Permitting and Inspections Department  
Michael A. Russell, MS, Director

**NOTICE OF VIOLATION AND ORDER TO CORRECT**  
**Sent by Certified and Regular Mail**

Re: 1567 Westbrook Street – CBL 256-B-001 – R-1 Residential Zone – Single-Family Dwelling

**Permit application #2689 - Shed Exansion, 1567 Westbrook St.**

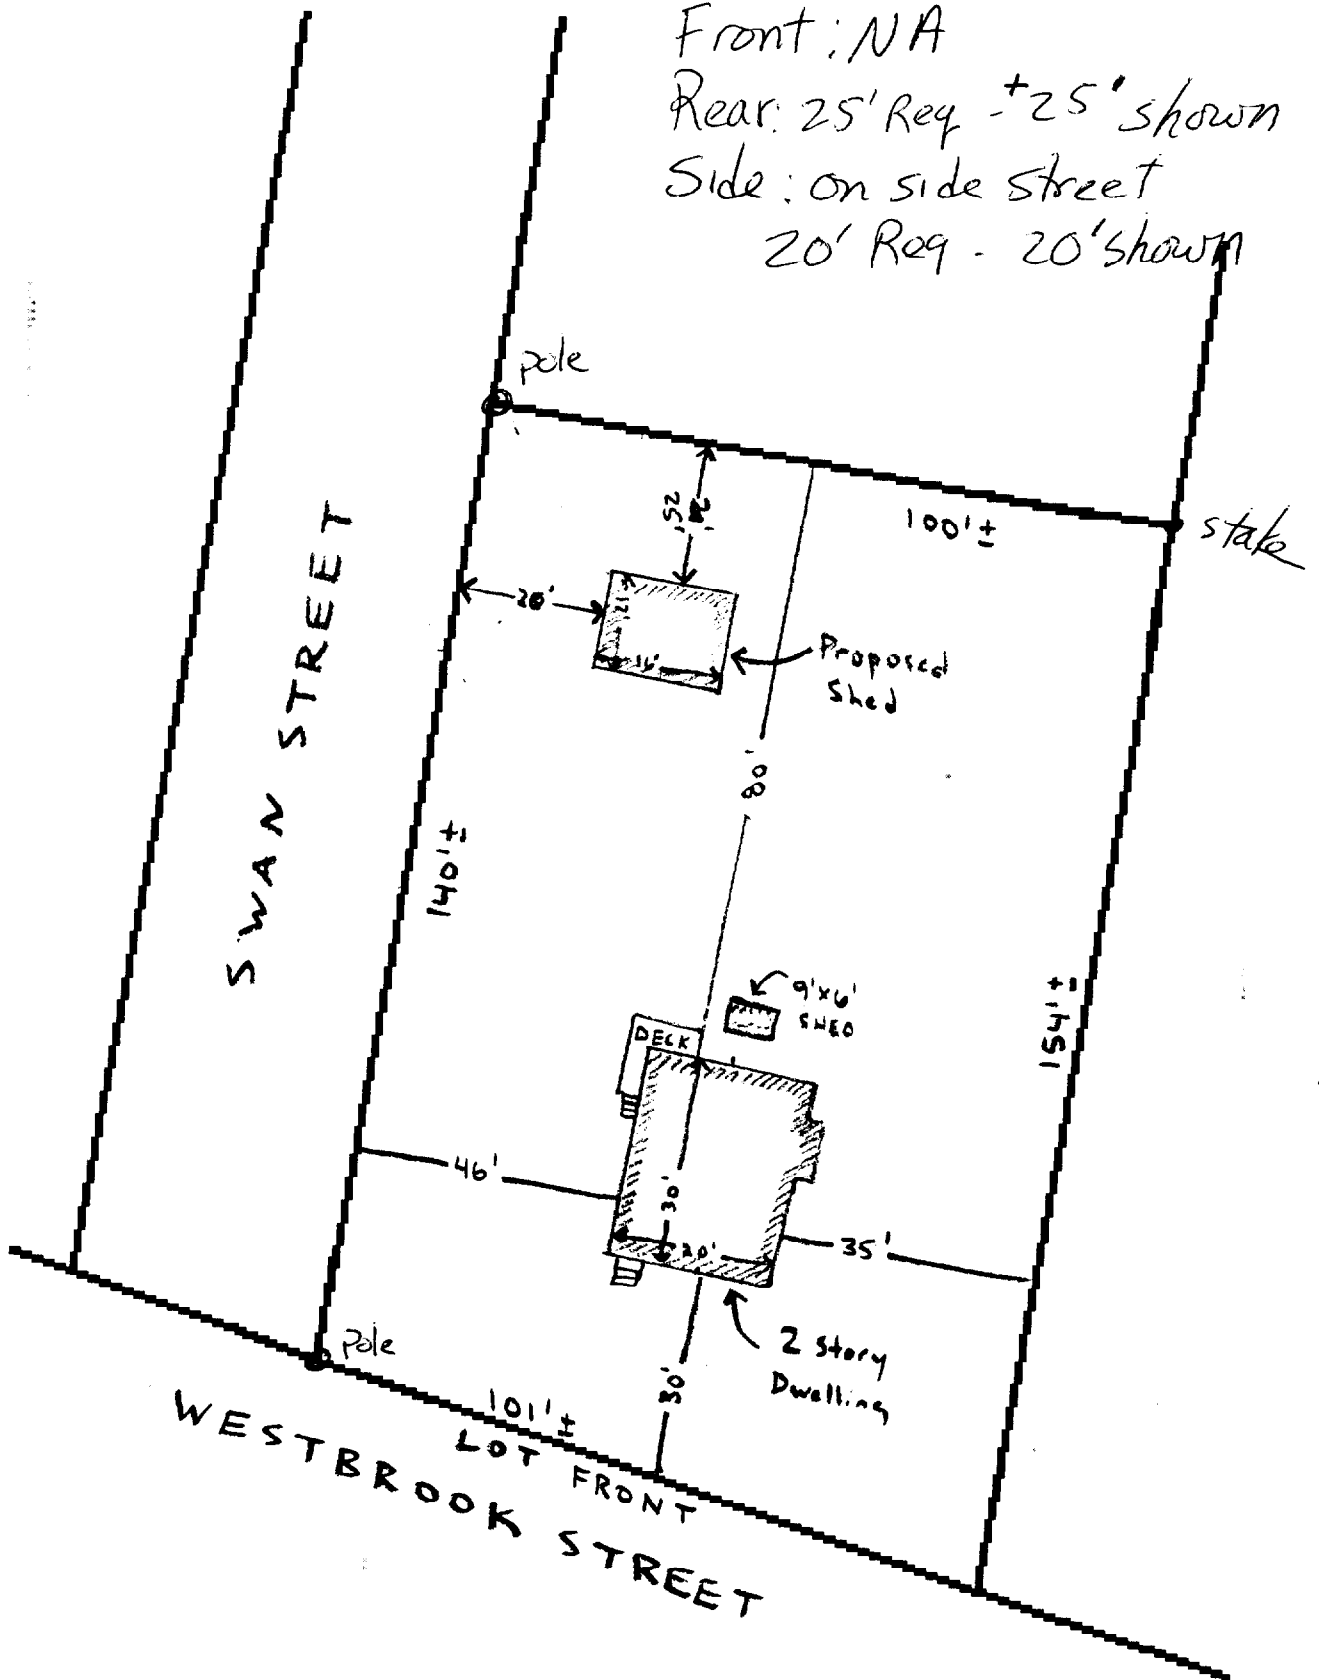
First, the plot plan showing the dimensions and setbacks is almost impossible to read because it is so blurry. Would it be possible for you to e-mail me a clearer version?

Regarding the setbacks, the plan appears to show a 21' setback to Swan Street. However, this seems to be the measurement to the street pavement, rather than to the actual property line, as required. The setback minimum to the side street property line is 20 feet. If the shed and addition do not meet this setback, they need to be relocated to meet the requirement.

I am also wondering about the rear setback. On the plan, it appears to say 9 feet, which is well below the 25' minimum setback required in this zone, and which was what we approved in the original shed permit (attached). Are you sure it is only 9 feet from the rear property line? It looks much further away in air photos.
